KITTITAS COUNTY

MEMORANDUM

TO: All Staff
FROM: Public Works Planning Review Team
DATE: January 13, 2021
SUBJECT: BL-20-00031 Ski Lifts

RECORD OF SURVEY
 A PORTION OF THE WEST 1/2 OF SECTION 15,
 TOWNSHIP 22 NORTH, RANGE 11 EAST, W.M., KITTITAS COUNTY, WASHINGTON

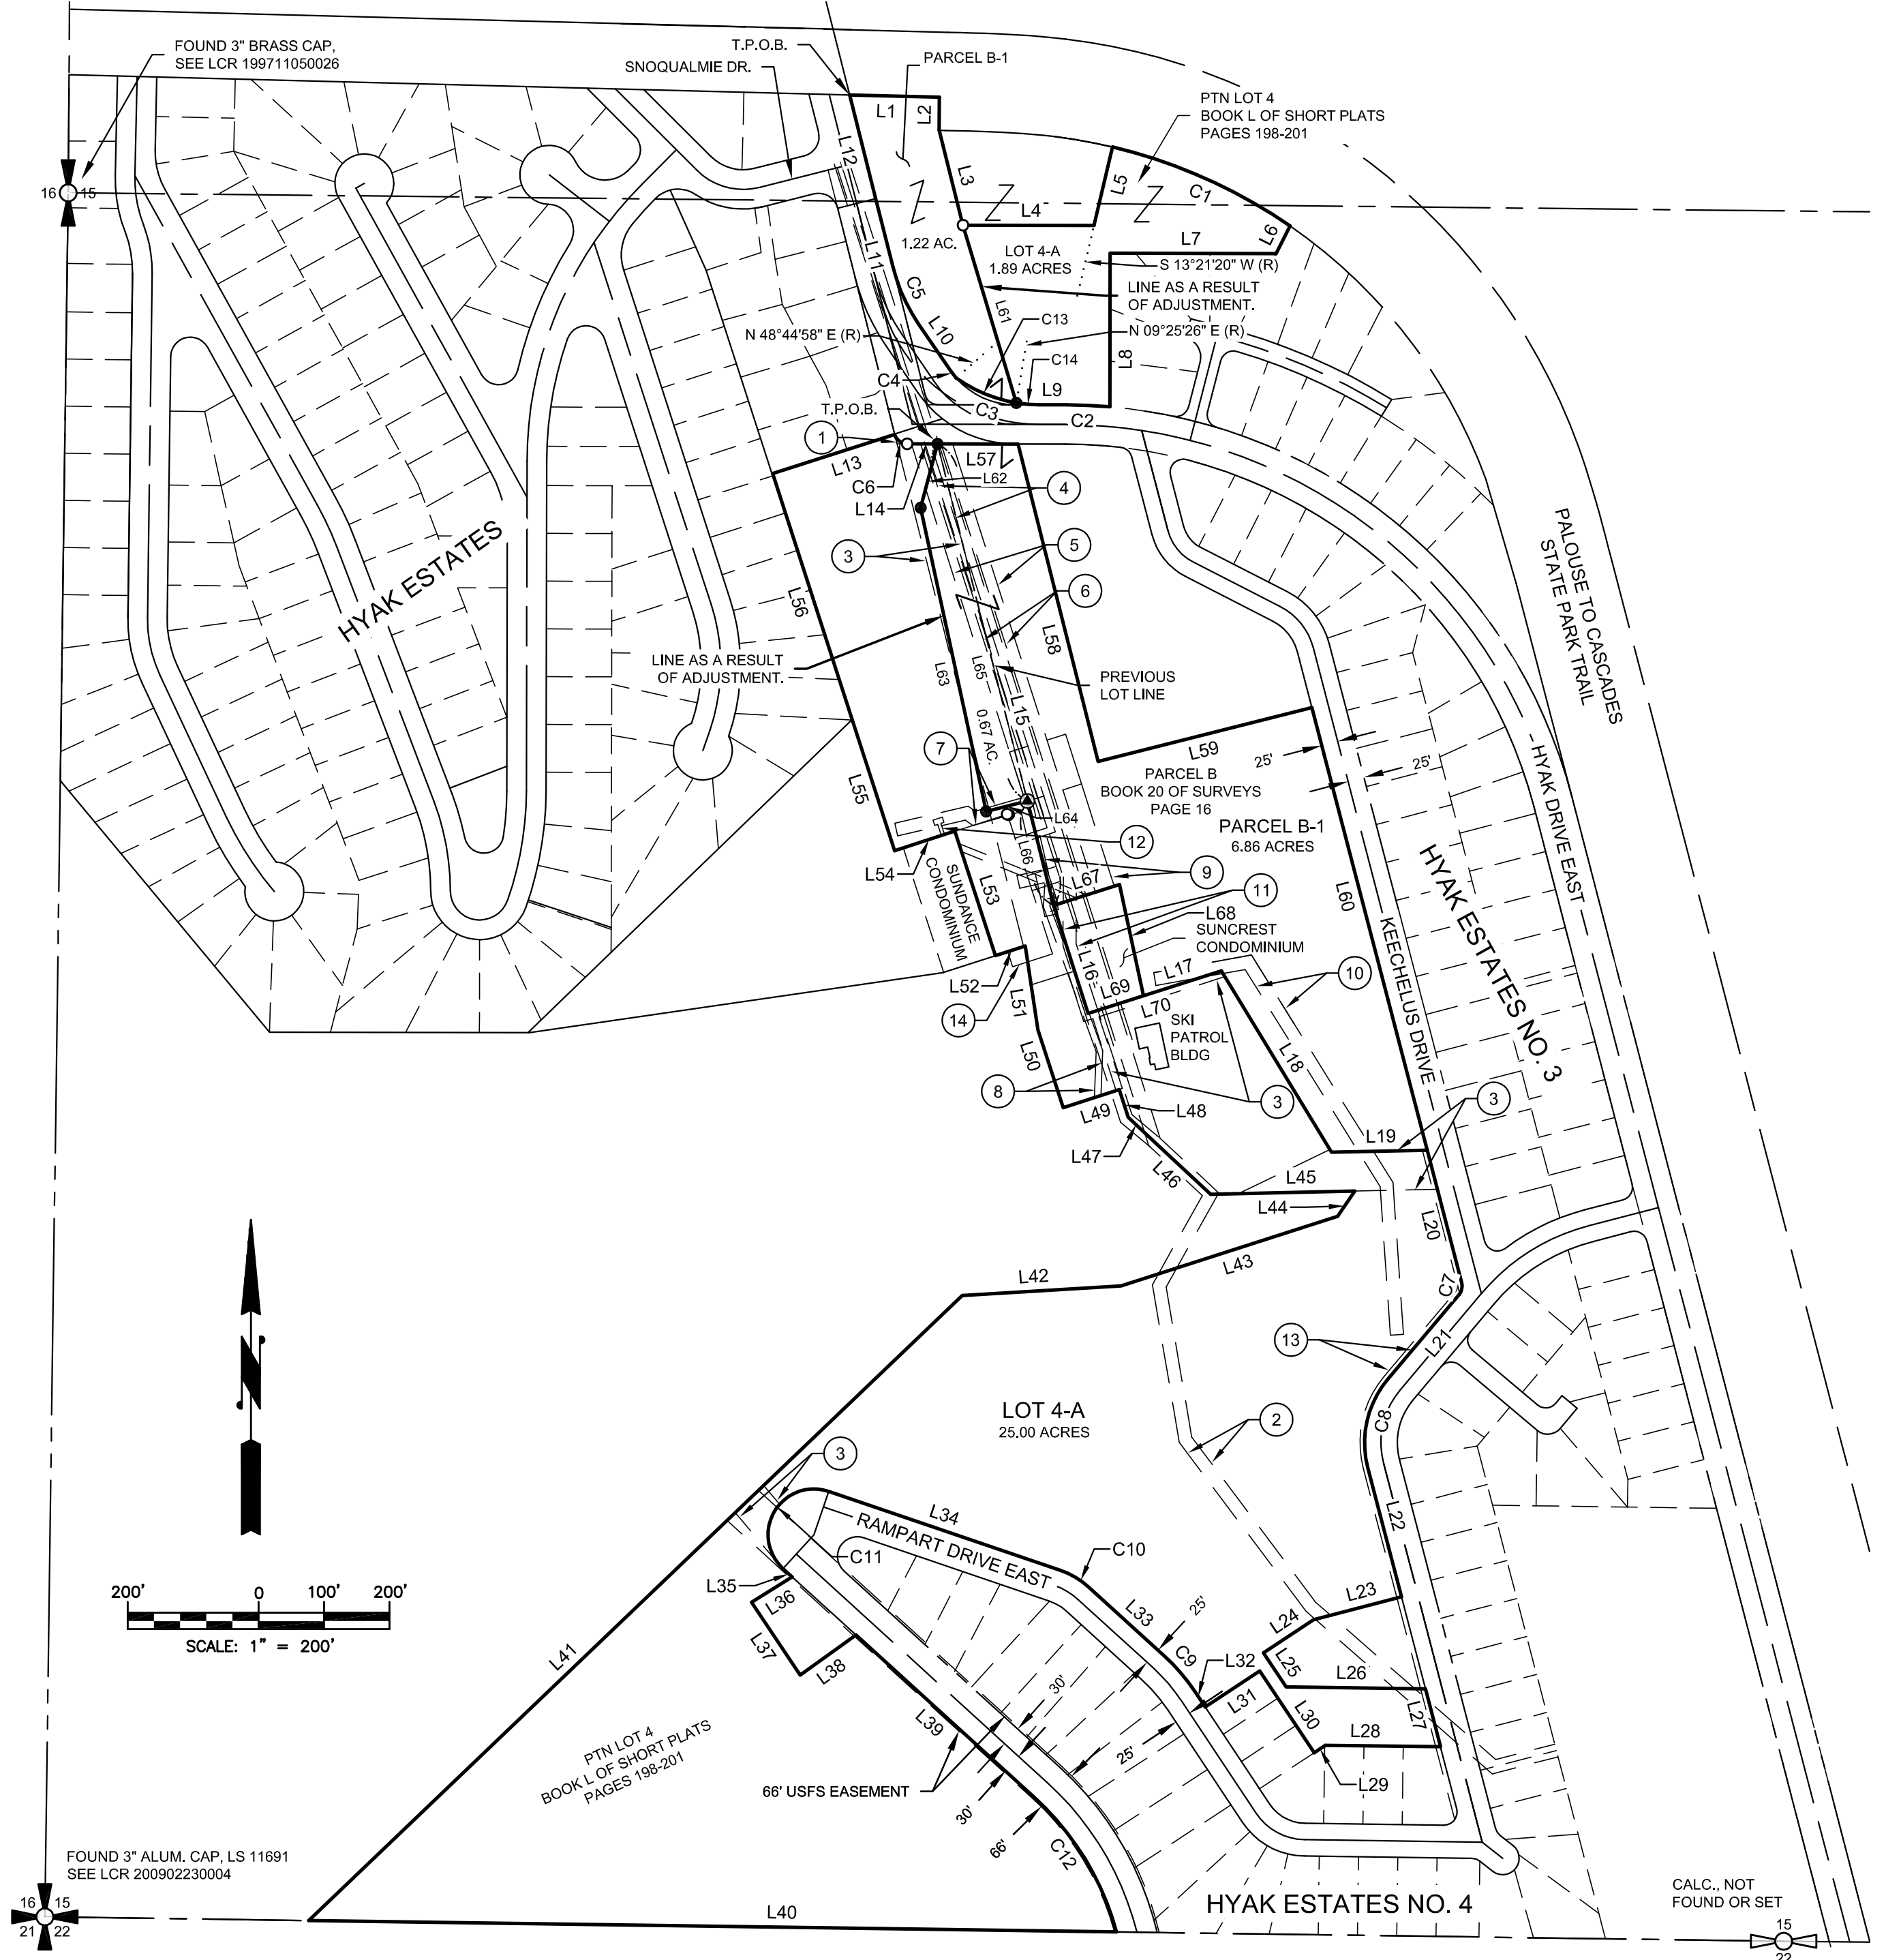
1. A revised legal description that describes the final configuration of the subject property shall be required.
2. A survey map for review.
3. Show access easements on the face of the BLA.

1. Section, Township and Range not shown at top of page.
2. Surveyor equipment and methods statement not shown.
3. Surveyor's and Auditors Certificate missing.
4. Missing Legend.
5. Basis of bearing missing.
6. Proposed Legal descriptions missing.
7. Roadways should include Name, width, ownership and surfacing
8. Purpose of survey with application number missing.
